Application No: FP/131/20/PD

Site Address: First Floor Office 44B Summerley Lane Felpham PO22 7HX

Description of works: Notification for Prior Approval under Class O for change of use from a use falling within Class B1(a)(offices), to a use falling within Class C3 (dwellinghouses) - change of use of the existing 1st Floor Office to a self contained Studio Apartment. This application is Not CIL Liable as flat in Zone 4.

Drawing Name:
Proposed Studio Flat Plan
Planning Application Drawing

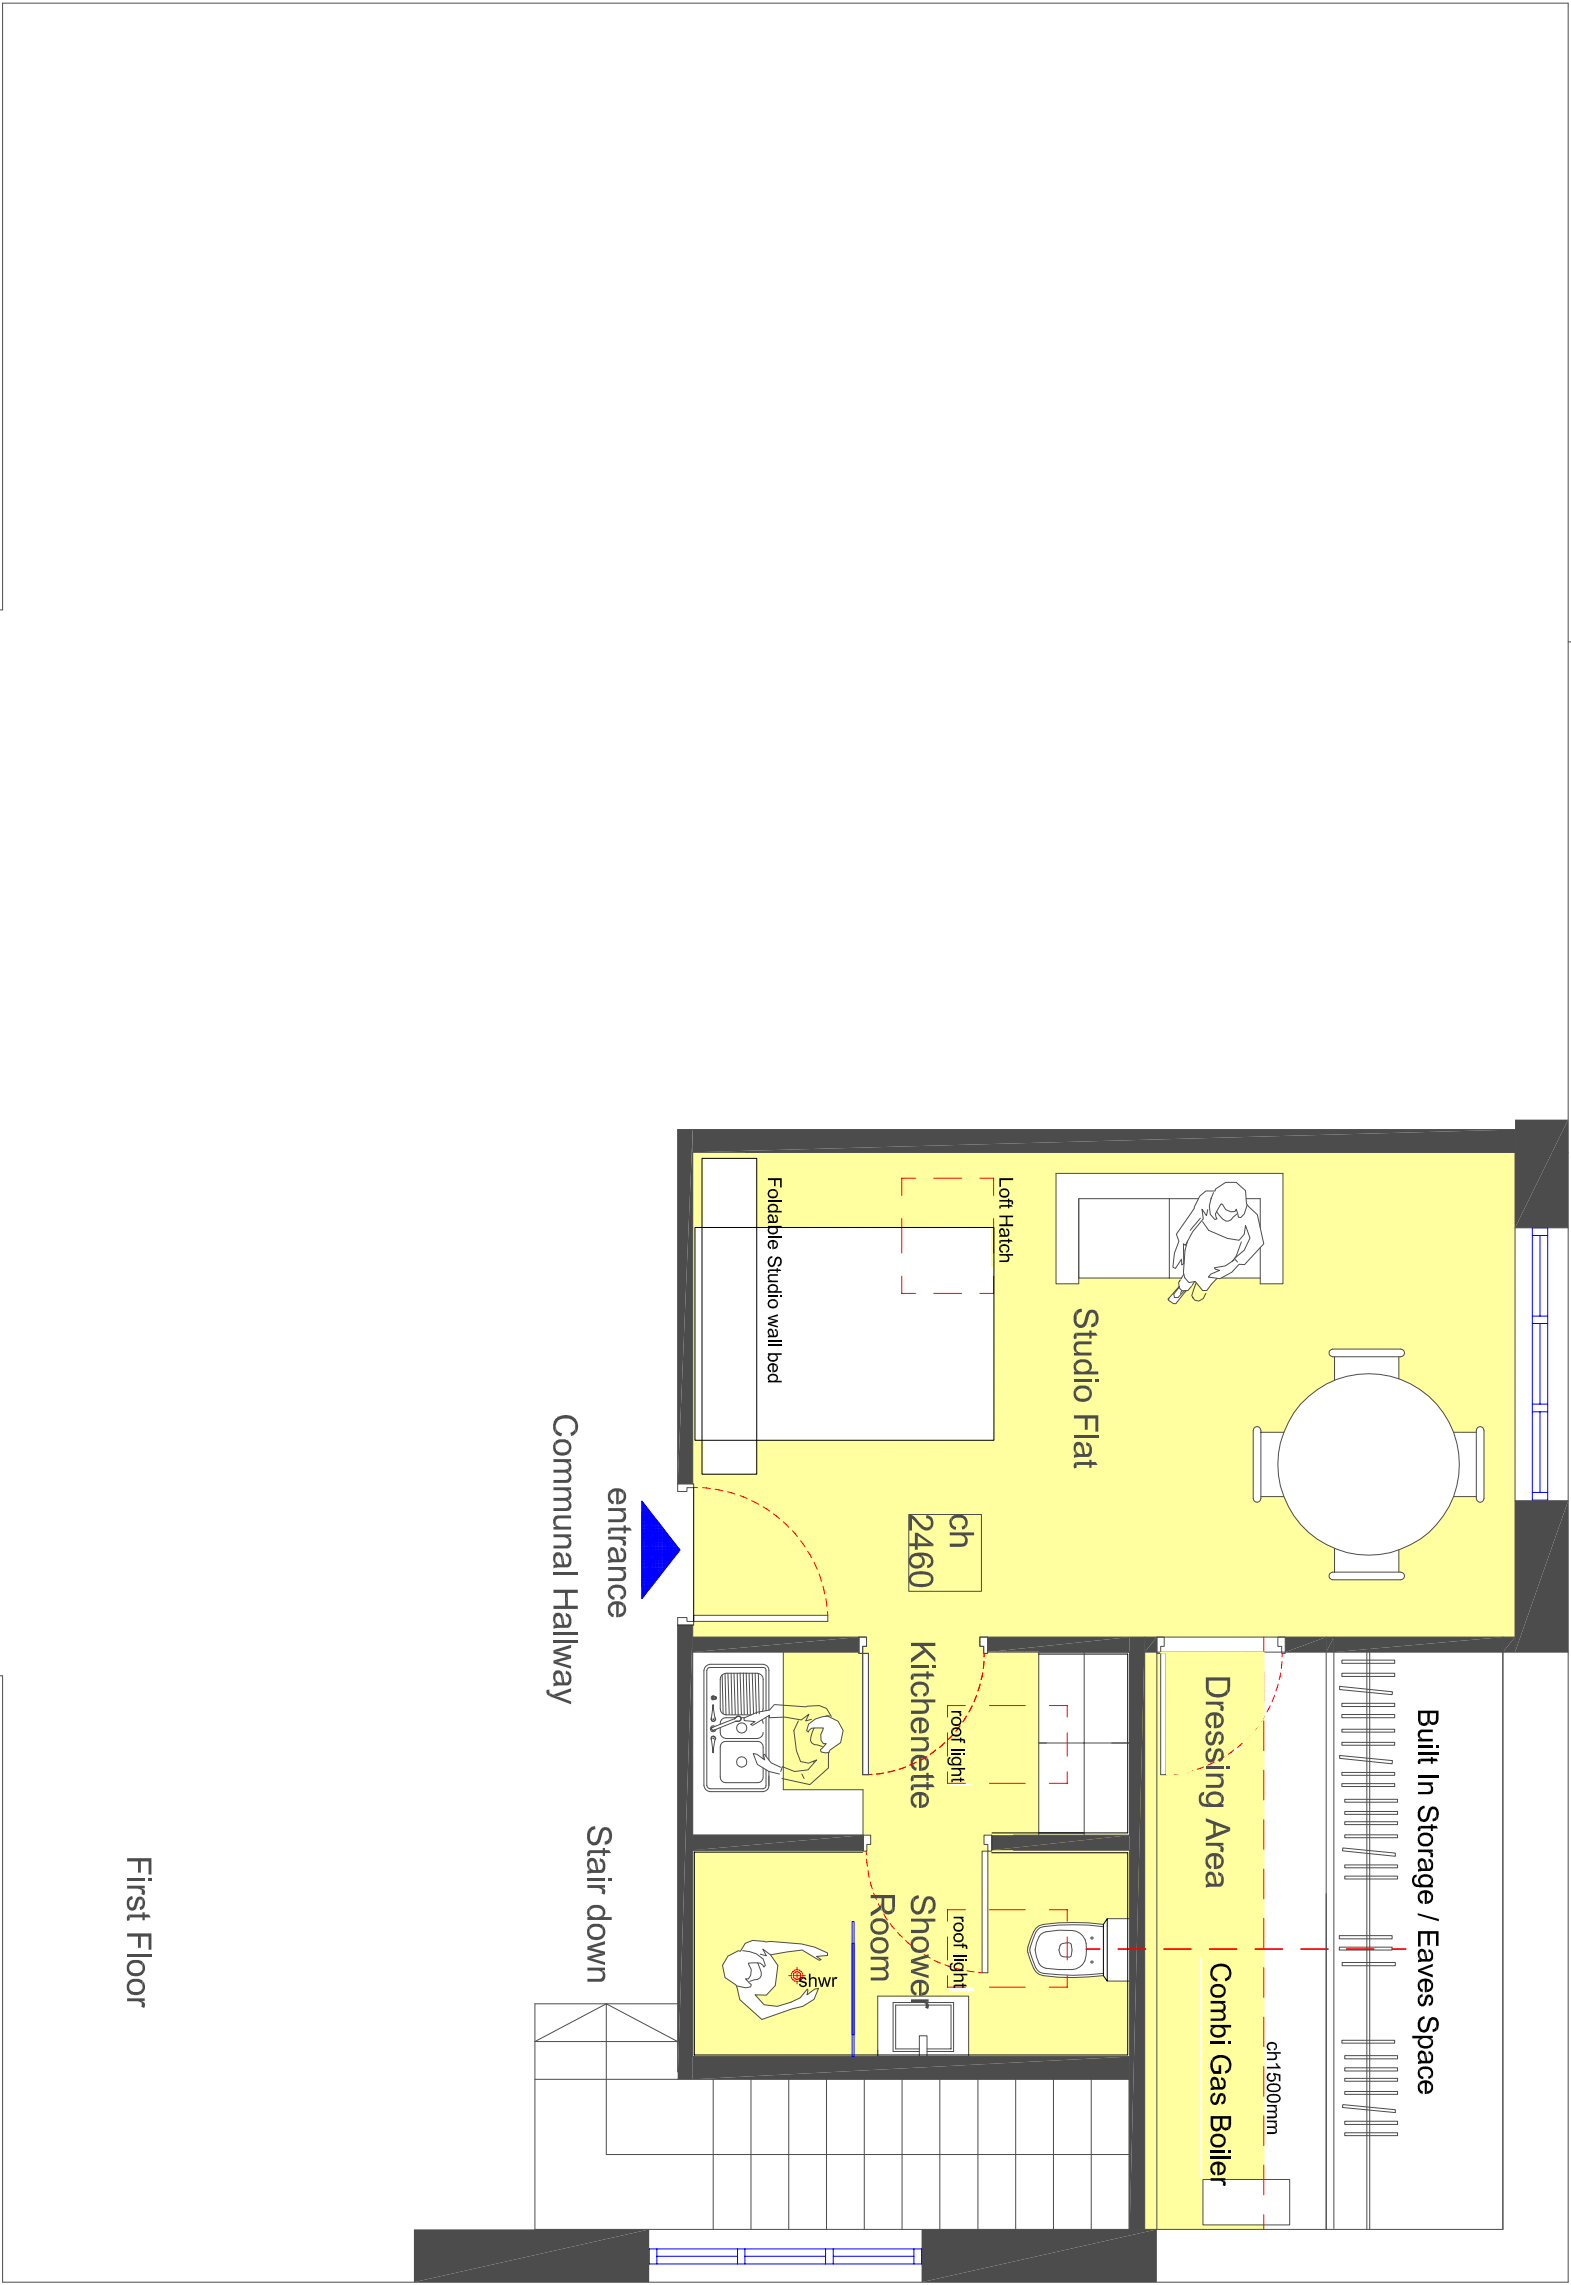
Objection - the plans do not appear to comply with Building Regulations/Standards as only 30sq - this would also set a precedence for other properties of similar small size.
